**RE: ROBERTS OIL (L15-D45). ENGINEER'S CERTIFICATION FOR  
CERTIFICATE OF OCCUPANCY. ENGINEER'S CERTIFICATION DATED  
AUGUST 16, 1996.**

DATE	8-15-96	JOB NO.	EM 4260
ATTENTION	LISA MANWILL		
RE:	ROBERTS OIL		
	LIS. D45		
	UNIVERSITY / GIBSON

**RE: ROBERTS OIL (L15-D45) DRAINAGE PLAN FOR BUILDING PERMIT.  
ENGINEER'S STAMP DATED 11-28-95.**

ROBERTS OIL
GRADING & DRAINAGE PLAN

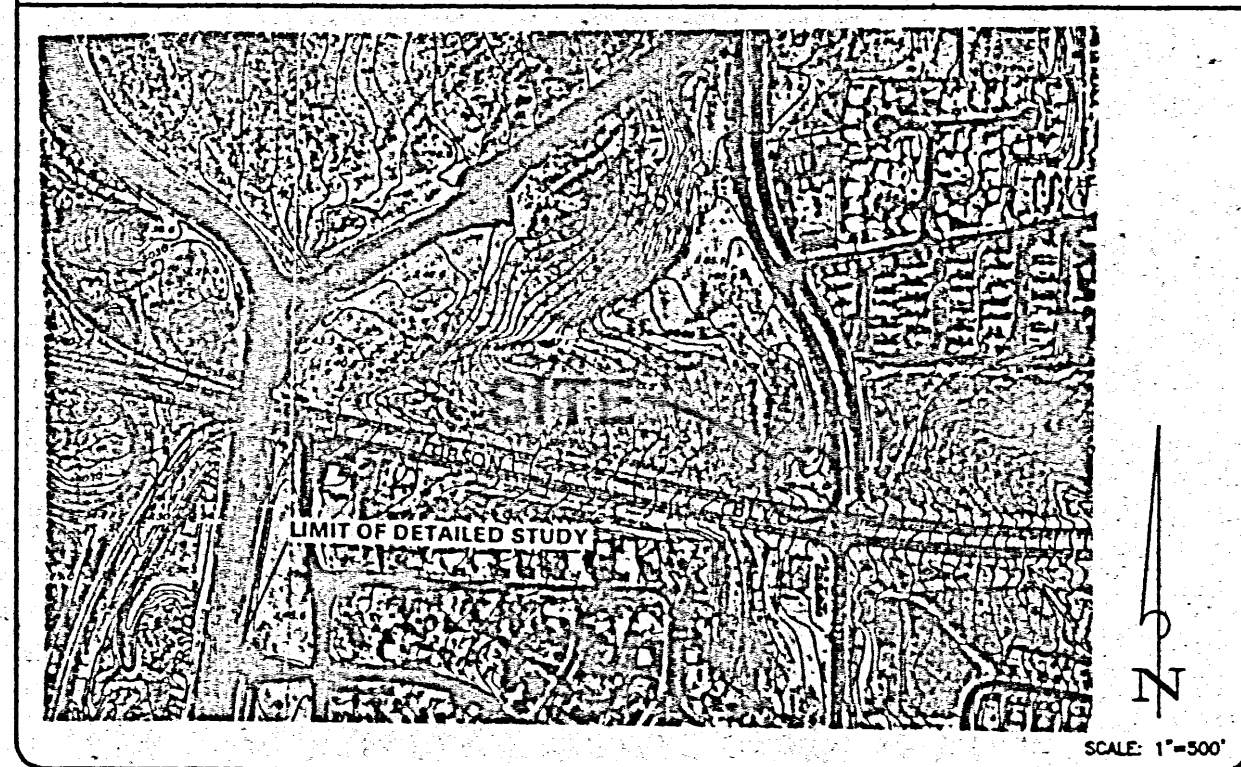
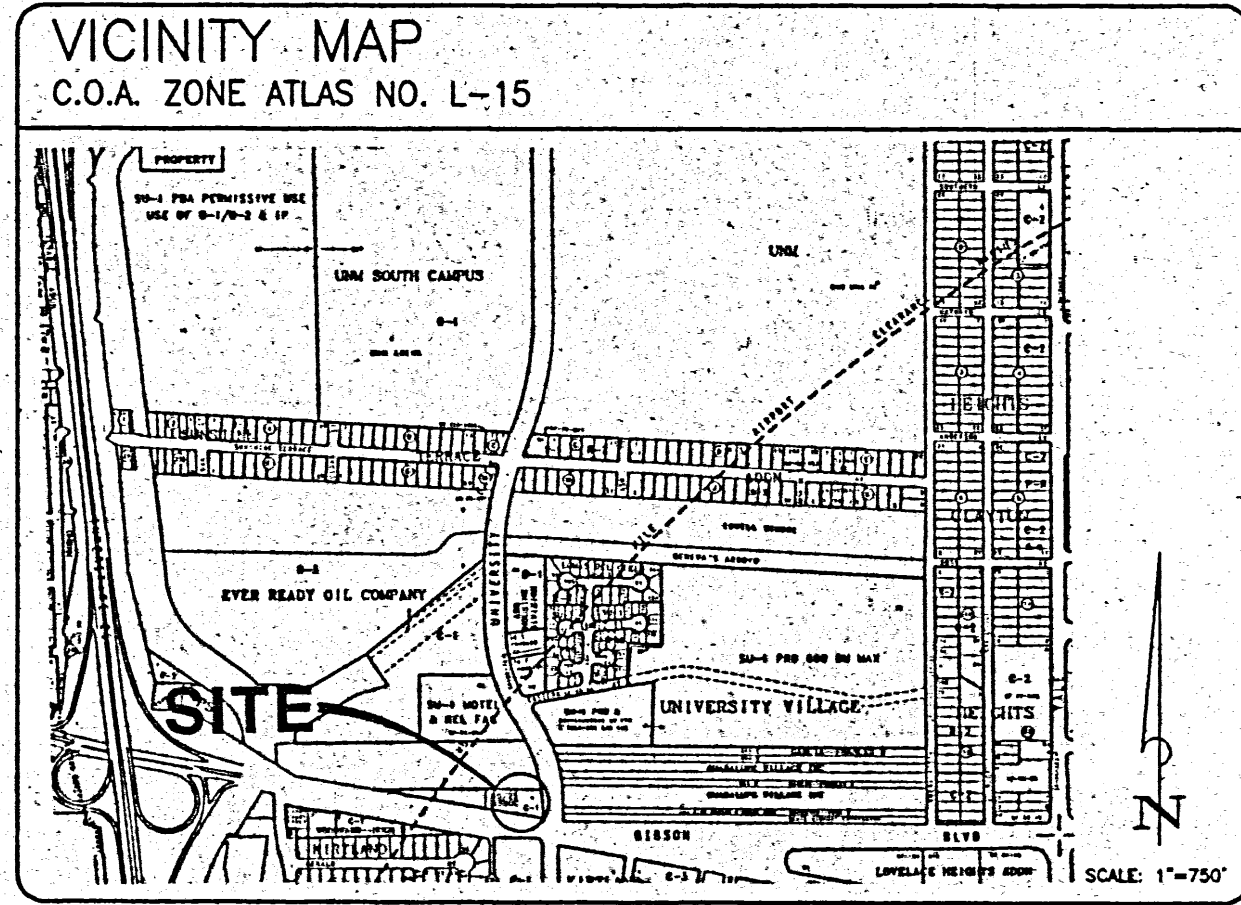
1. Please provide this office with a copy of the plat describing the private drainage/access easement.
2. Portion of the landscaping adjacent to Gibson Blvd. drain over the sidewalk and then into the street. Sheet flow over a public sidewalk is not allowed.
3. It appears that the east side of the driveway along Gibson has approximately a 0.50 foot water block. A minimum 1 foot water block is required.
4. The City suggests that the area around the fueling bays and under the canopy be graded so that in the future the fueling area can be contained and all washdown water collected and routed to an oil/water separator. This separator would be connected directly to the sanitary sewer, not to the storm drain. The City is currently modifying requirements for fueling areas and the above suggestion for containment of runoff may become standard.

For improved water quality, the City would prefer a grass or gravel area be installed in the southwest corner of the site for infiltration/evaporation. Free discharge would continue to occur from your site.

I HAVE ADDRESSED COMMENTS 1, 2, 3 & 5.  
THE OWNER DO NOT WISH TO PARTICIPATE  
WITH COMMENT 4.  
IF YOU HAVE ANY QUESTIONS, PLEASE CALL
